Recommendation Report for Planning Permission for Works or Extension to a Dwelling

REF NO: WA/109/19/HH

LOCATION: 1 The Meadows
Walberton
BN18 0PB

PROPOSAL: New single storey side extension with mono-pitched roof.

title: Proposed Elevations		
project no: 2019/022	drawing no: 12	revision: /
date: 14.11.2019	scale: 1:50 @ A1	drawn: CT
drawing status: PLANNING

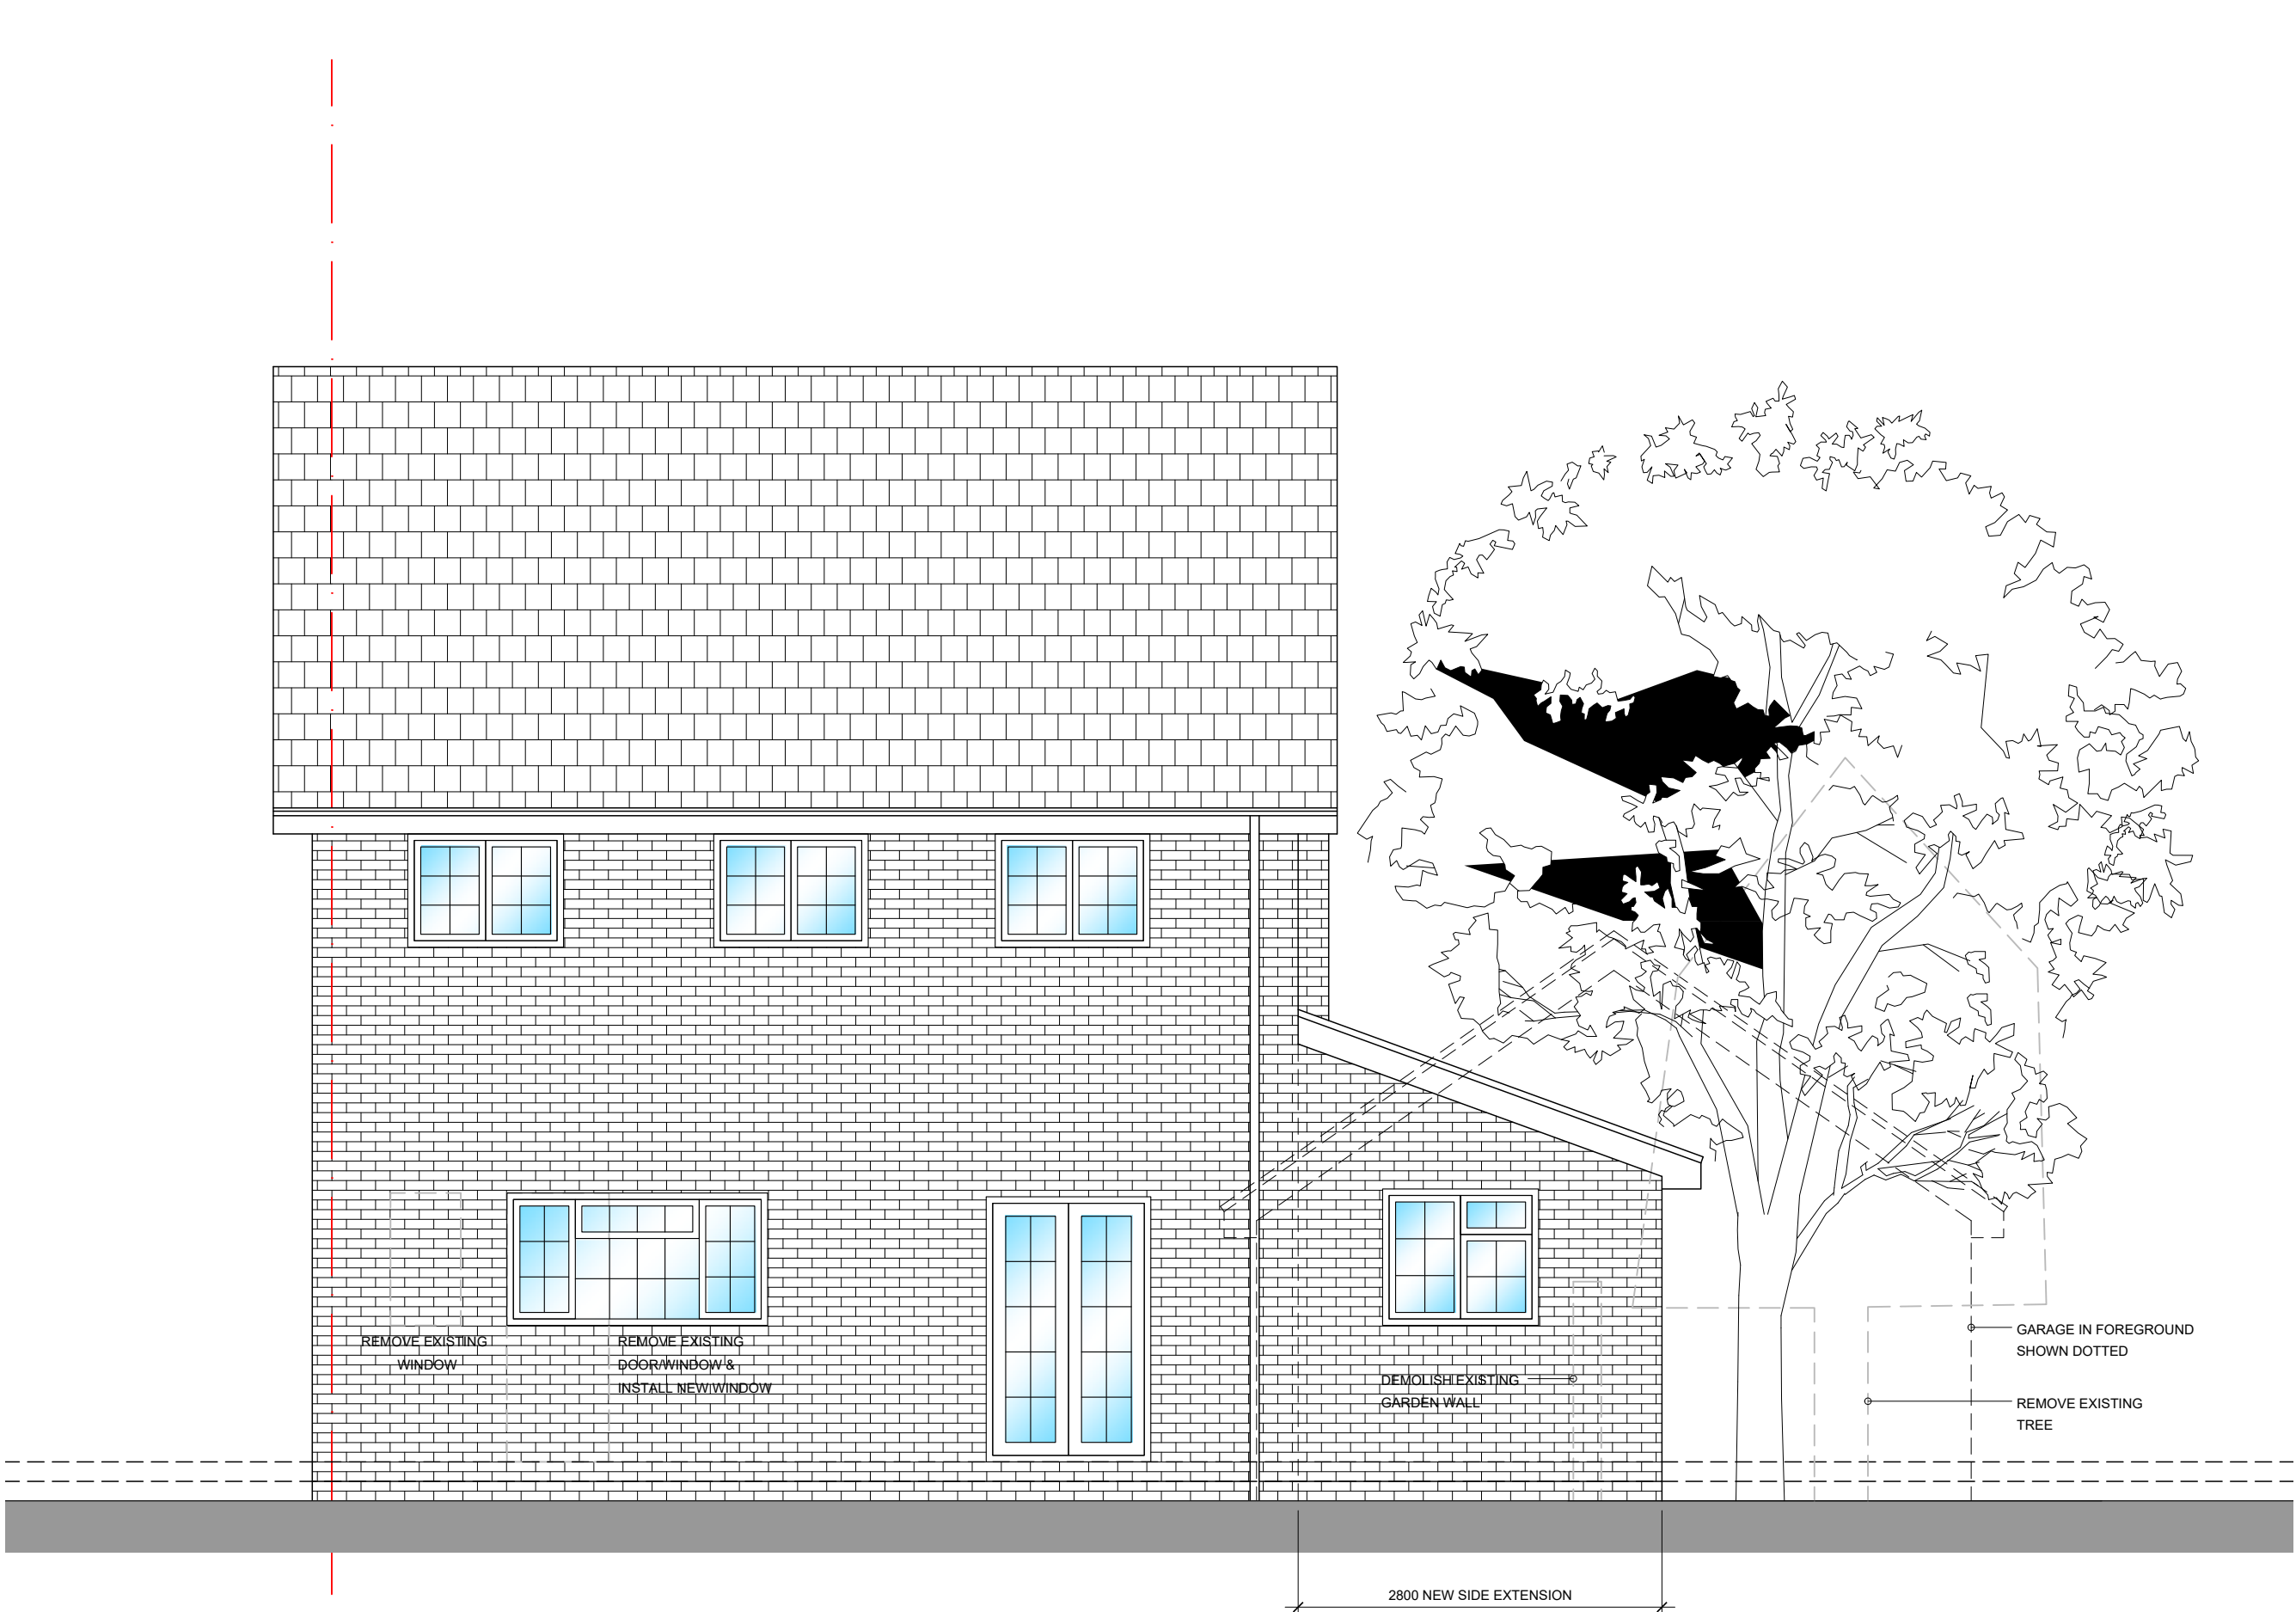
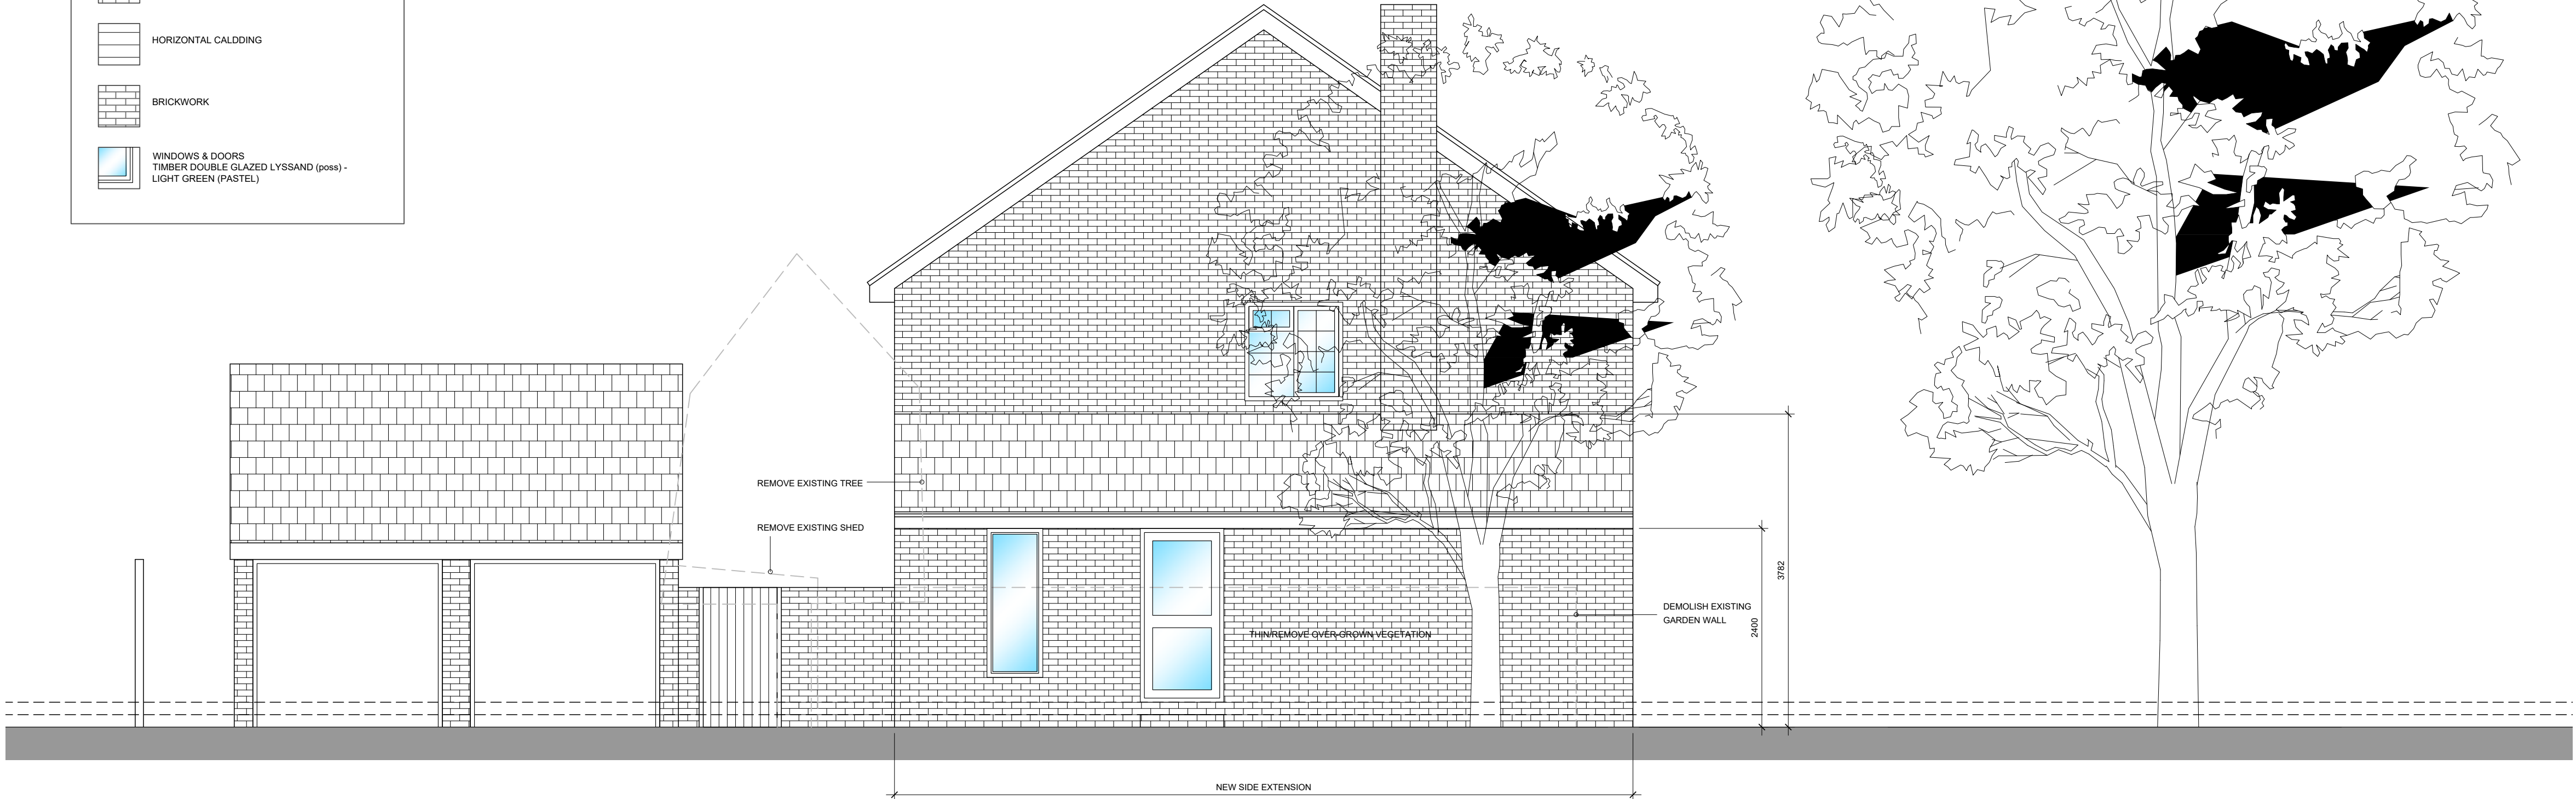
The proposed development will be visible within the street scene, due to its siting and the fact that the proposal includes the removal of the existing foliage, and boundary which currently borders this elevation. However, the proposed extension is not considered to appear as an alien, or overly intrusive feature within the locality, largely as a result of the proposed materials, and the modest scale of the proposal. Furthermore, the proposed development is sited approximately 5m from the street scene, which is considered to further mitigate any potentially harmful impact of the proposed development upon the public realm.
